From: Michael Eastham <Michael.Eastham@arun.gov.uk>
Sent: 15 May 2020 11:03
To: Planning.Responses <Planning.Responses@arun.gov.uk>
Subject: FW: Planning Consultation on BE/21/20/DOC - Salt Box

Subject: RE: Planning Consultation on BE/21/20/DOC

APPLICATION NO: BE/21/20/DOC

Site Address: Land At Salt Box West Of Shripney Road Bognor Regis PO22 9NW

HYDROCK PROJECT NO.		SCALE @ A1
C-13319-C		1:250
STATUS DESCRIPTION		STATUS
TENDER		D2
DRAWING NO. (PROJECT CODE-ORIGINATOR-ZONE-LEVEL-TYPE-ROLE-NUMBER)		REVISION
SAL-HYD-PH2-ZZ-DR-C-7010		P03

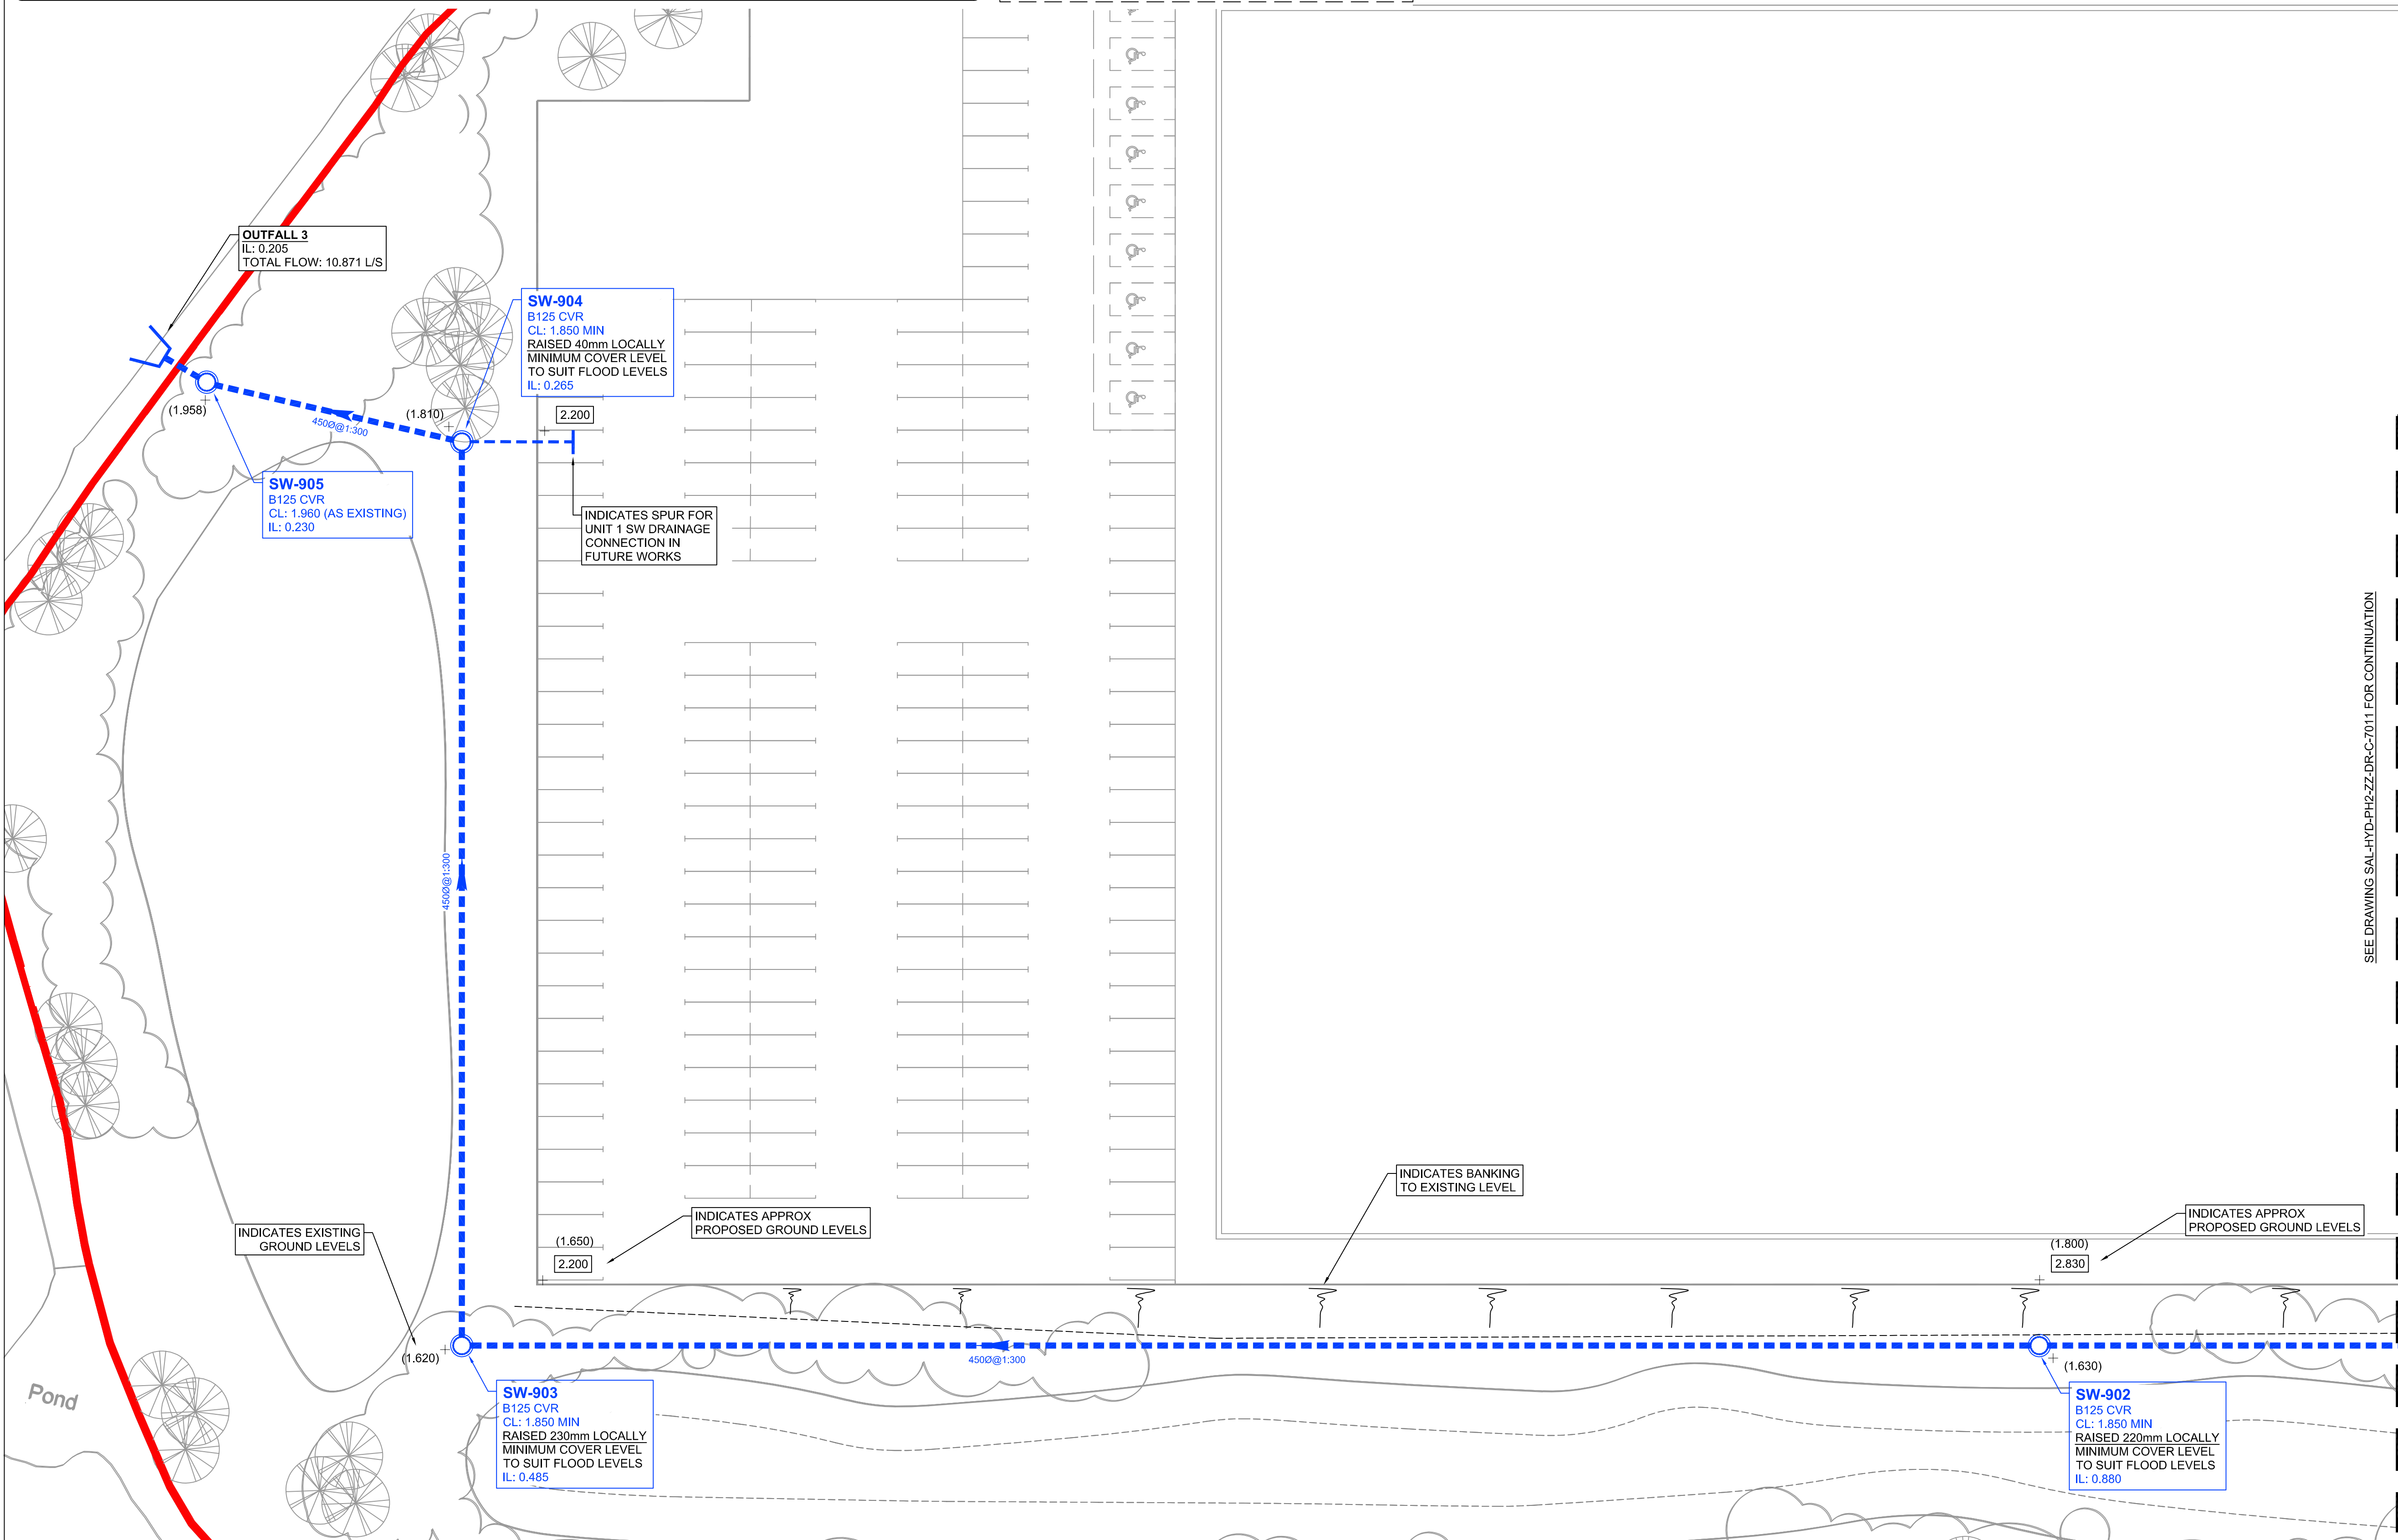
14. Drawing 7010 – specify sub base levels for ALL permeable paving areas. On drawing 7300 – add note to refer to sub base levels on drawing 7010.
Sub base levels added To 7010 and note added to 7300. ok

15. Drawing 7010 - SW-405 to tank – specify pipe diameter and a reasonable gradient.
Gradient added ok
16. Drawing 7103 (Phase 2)– Section 2-2 – should this be labelled AT-401?
401 label added. ok

HYDROCK PROJECT NO. C-13319-C		SCALE @ A1 1:250	
STATUS DESCRIPTION TENDER			STATUS D2
DRAWING NO. (PROJECT CODE-ORIGINATOR-ZONE-LEVEL-TYPE-ROLE-NUMBER) SAL-HYD-PH2-ZZ-DR-C-7011			REVISION P03

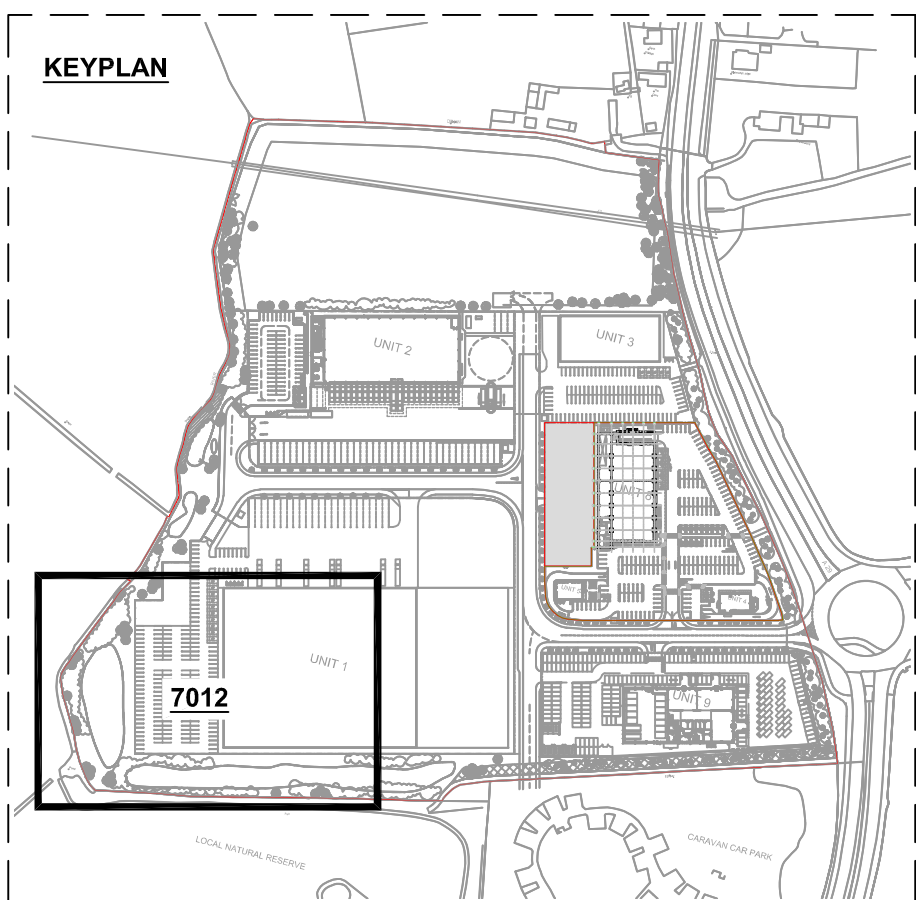
7. Manhole SW-900 invert level is different on plans 7011 and 7022. Noted.
PH1-7022 IL revised to suit PH2-7011. ok
8. Provide detailed headwall construction details for outfall no.3. This will also require Land Drainage Consent from myself since the connection is being made to an ordinary watercourse. See enclosed application form and guidance notes.
Phase 2 headwall detail added. Drawing 7111 noted, however, outfall has been labelled 2 rather than 3.

9. Drawings 7011 and 7012 – Remove any trees etc being shown within proximity of the proposed pipeline.
Noted. Trees removed. ok
10. Improve gradient FC-401 to 01-401 to min 1 in 400.
Pipe gradient updated. ok

DETAIL PG: PAVED GULLY
SCALE 1:10

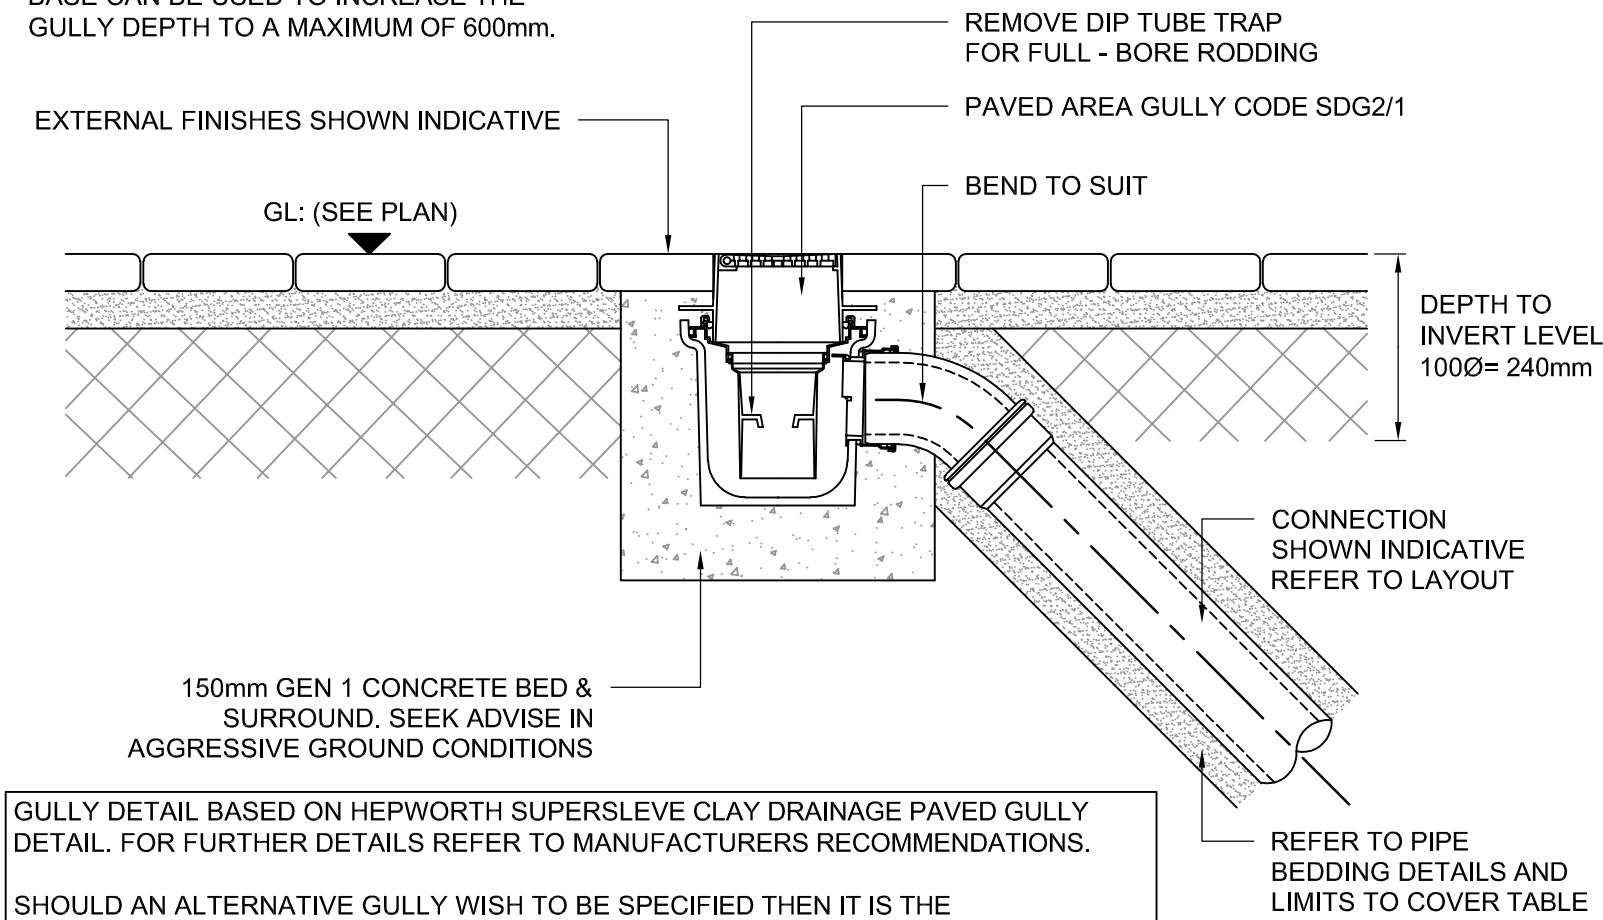
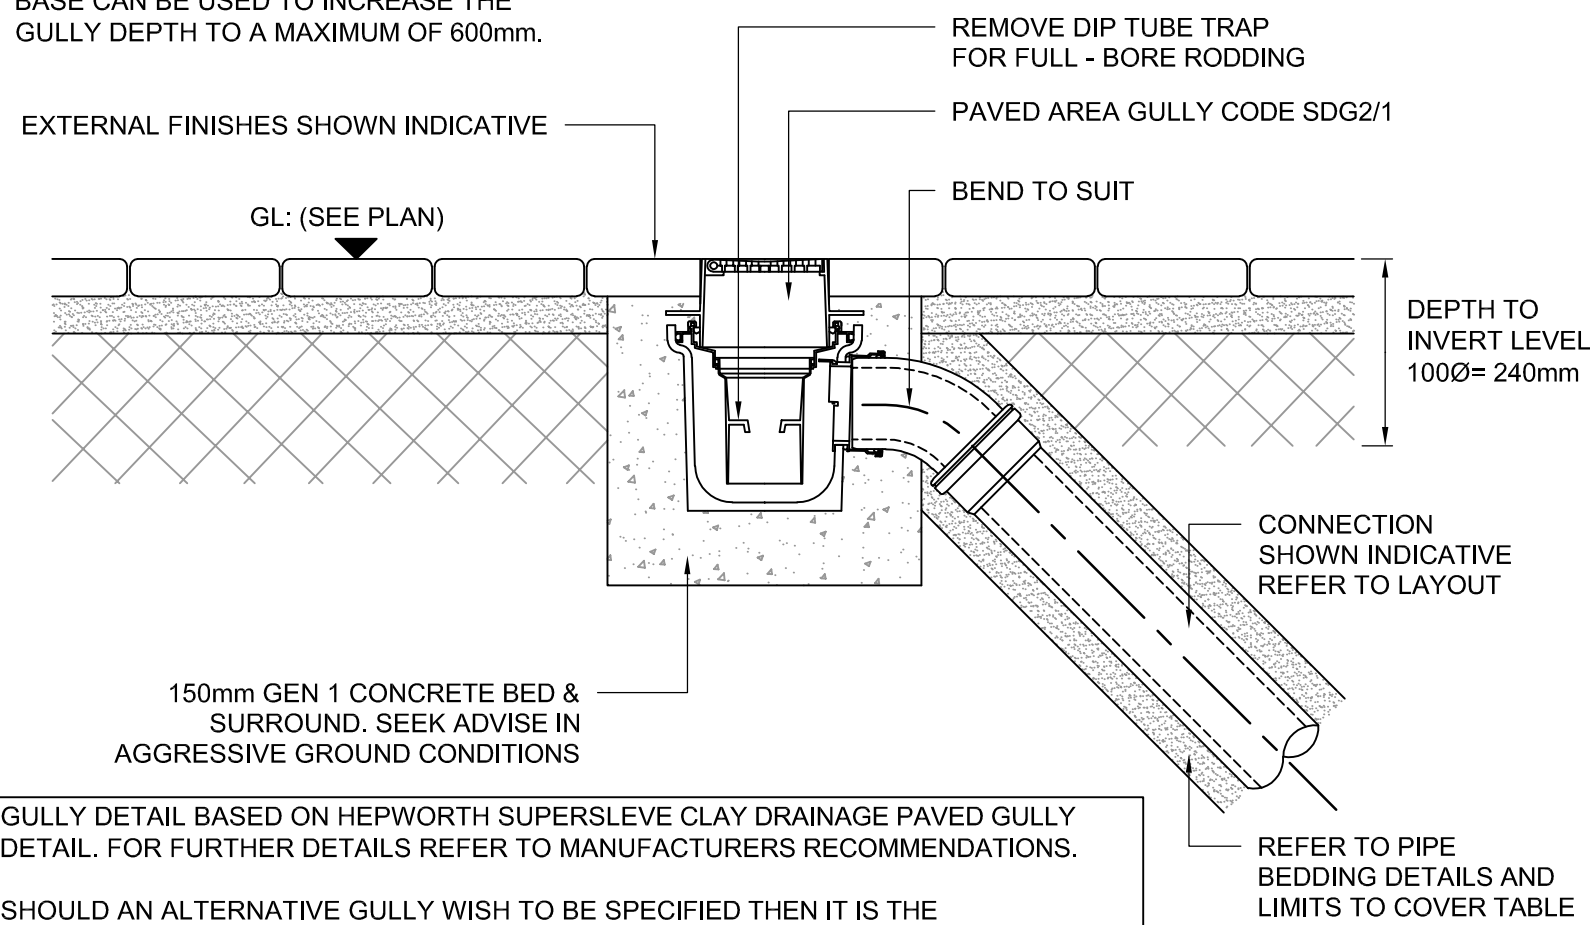
11. Specify gradient and pipe diameter (FC-401 to SW-1000) on drawings 7010 and 7021.
Pipe gradient added ok
12. Provide PG paved area gully construction detail (to incorporate silt trap).
PG detail added ok

UNIT 4-8 FC-401
FLOW CONTROL IN CIRCULAR MANHOLE
SCALE 1:20

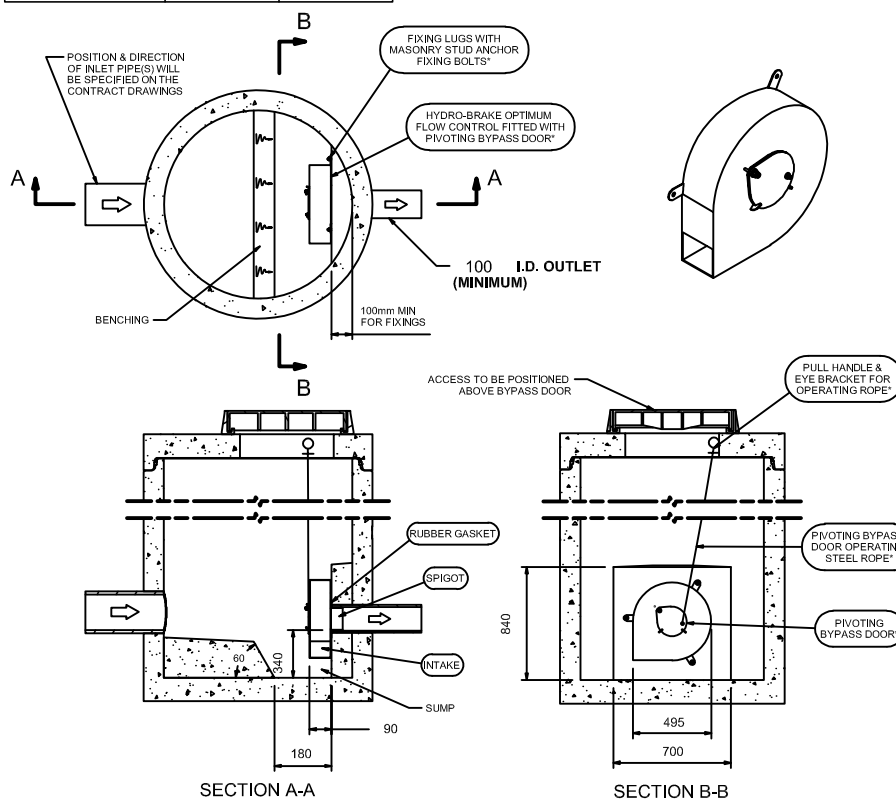
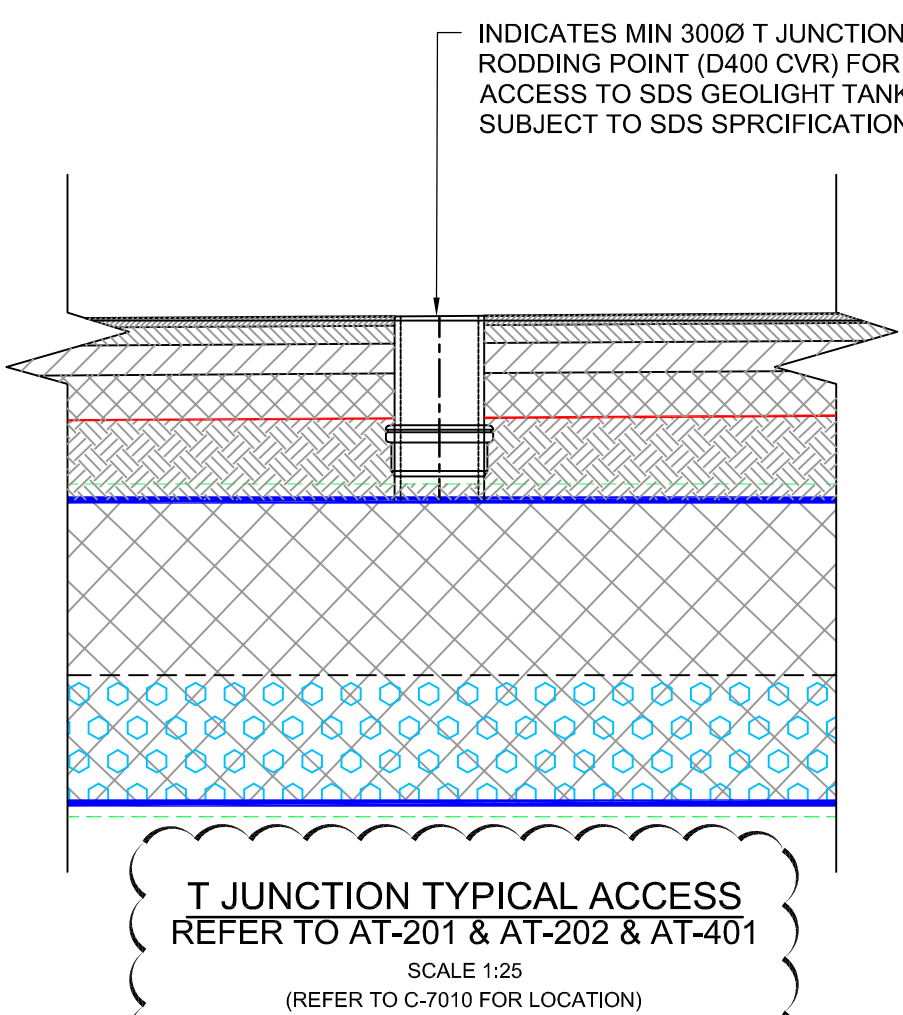
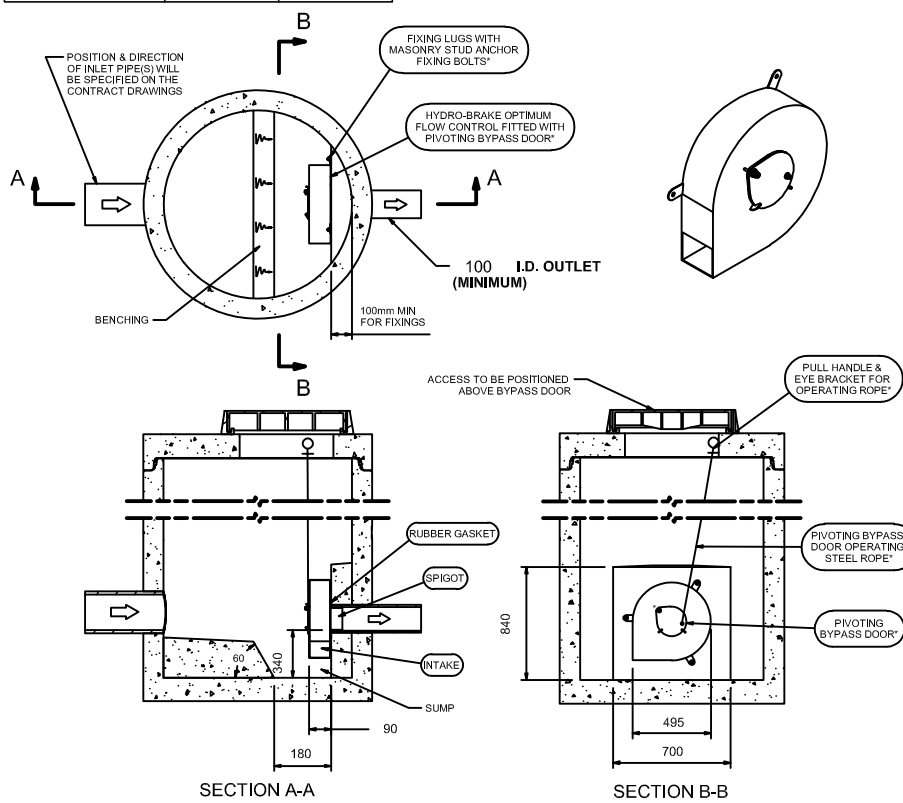
22. FC-401 – specify hydrobrake model and discharge on drawing 7103 (Phase 2)
Full detail can be found on drawing 7103. Flow note added. Now shown on 7101 but hydrobrake model not indicated?
